May 14, 2021

Planning Application for Non-Material Amendment to permission (appeal ref) W/4000394 (application ref Y/103/18/PL) for Single Chapel Crematorium with car parking, landscape works, surface water drainage features and associated highway improvements

DRAWING TITLE
Approved Plan Layout Comparison

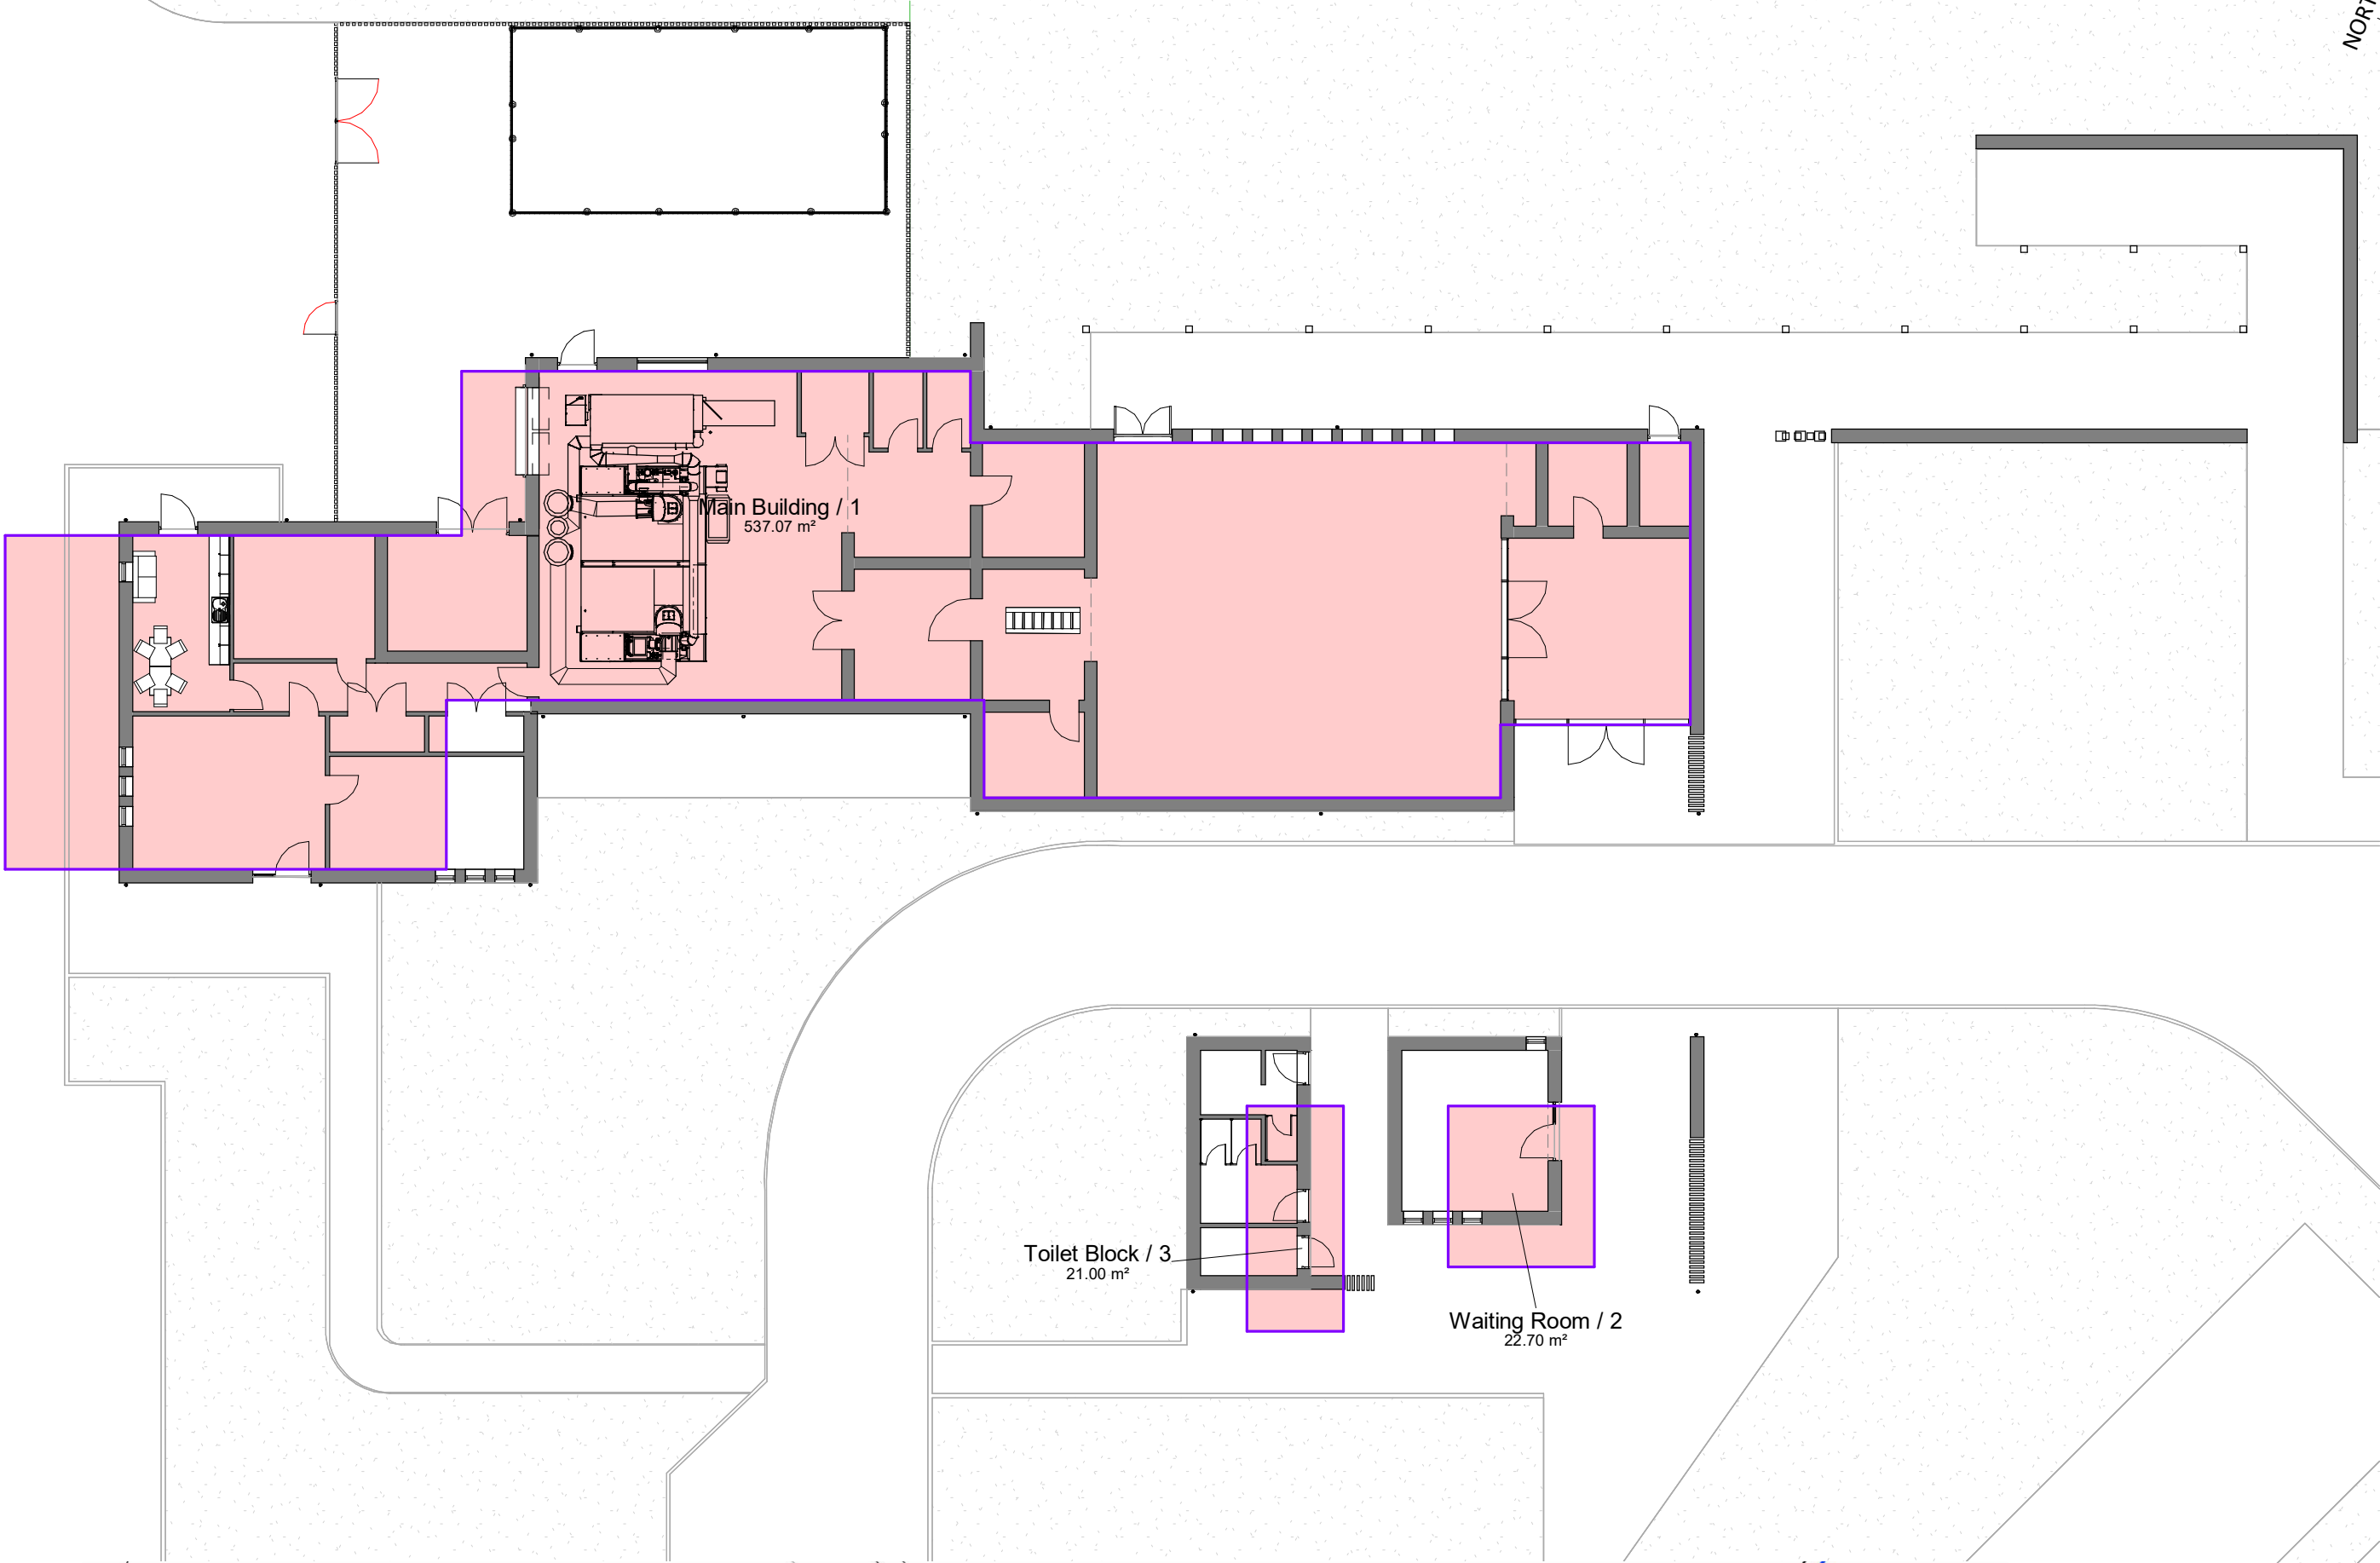
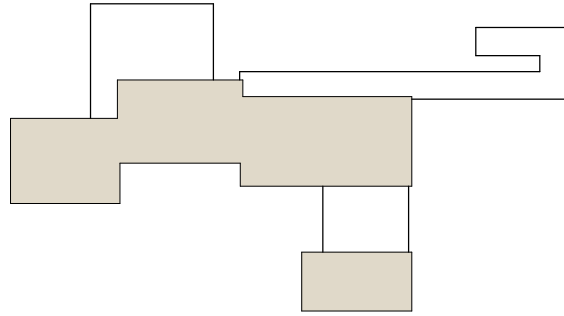
This letter supports the application for the proposed amendments that the operators Westerleigh are seeking in their proposal and are submitted formally through the planning portal. As before, the package of drawing includes useful overlays to compare the approved and proposed schemes, in particular drawing **154389_SK01_A_PL01 Approved Plan Layout Comparison** which has a site and building comparison overlay.

- There would be no increase in width or length
- The floorspace overall reduces from the approved area of 580.77sqm to 576.59sqm this slight reduction of 4.18sqm.
- We do not believe that this change would warrant consultation with any neighbour or statutory body
